## EL PASO COUNTY GRADING AND EROSION CONTROL PLAN CHECKLIST

EPC Project Number:

Revised: July 2019

APPENDIX 5: Erosion & Sediment Control Plan (ESC Plan) – Site Map

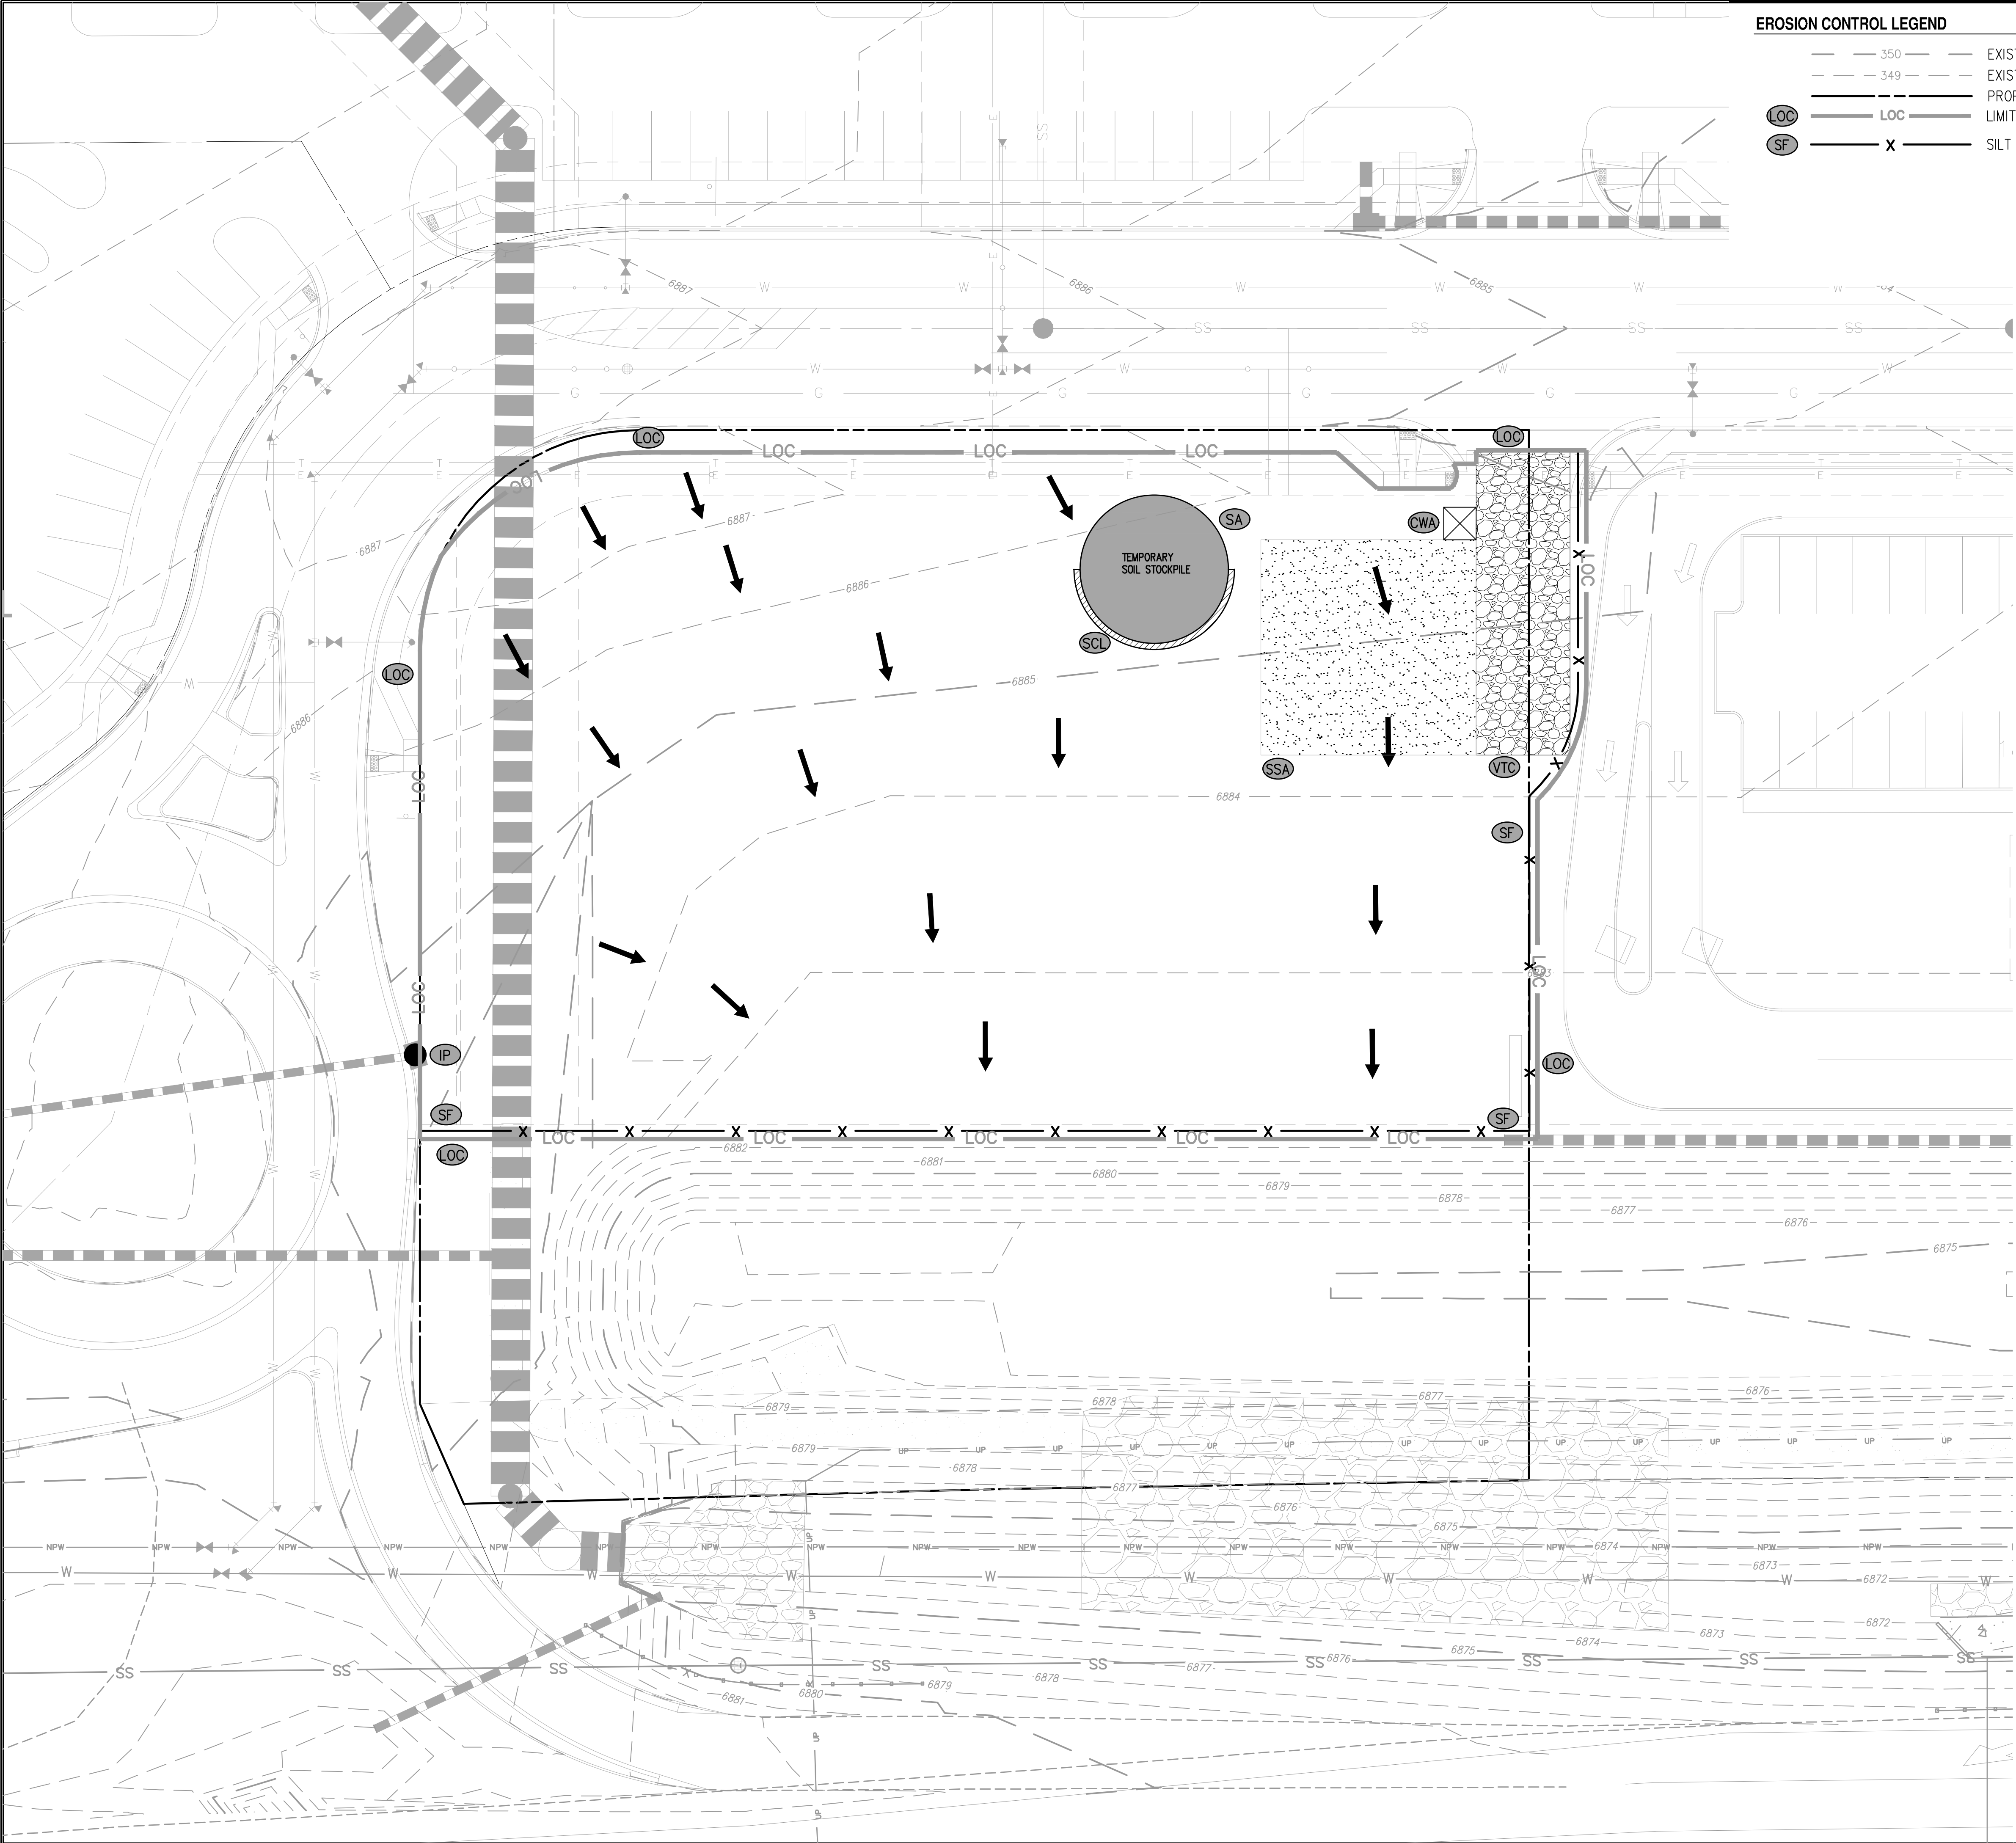
l	Existing and proposed contours 2 feet or less (except for hillside)		Y
m	Limits of disturbance delineating all anticipated areas of soil disturbance		N
n	Identify and protect areas outside of the construction site boundary with existing fencing, construction fencing or other methods as appropriate		N/A
o	Off-site grading clearly shown and called out		N/A
p	Areas of cut and fill identified		Y
q	Conclusions from soils/geotechnical report and geologic hazards report incorporated in grading design (slopes, embankments, materials, mitigation, etc.)		Y
r	Proposed slopes steeper than 3:1 with top and toe of slope delineated. Erosion control blanketing or other protective covering required		N/A
s	Stormwater flow direction arrows		Y
t	Location of any dedicated asphalt / concrete batch plants		N/A
u	Areas used for staging, storage of building materials, soils (stockpiles) or wastes. The use of construction office trailers requires PCD permitting		Y

Move all of these notes to the standalone GEC Plan set.
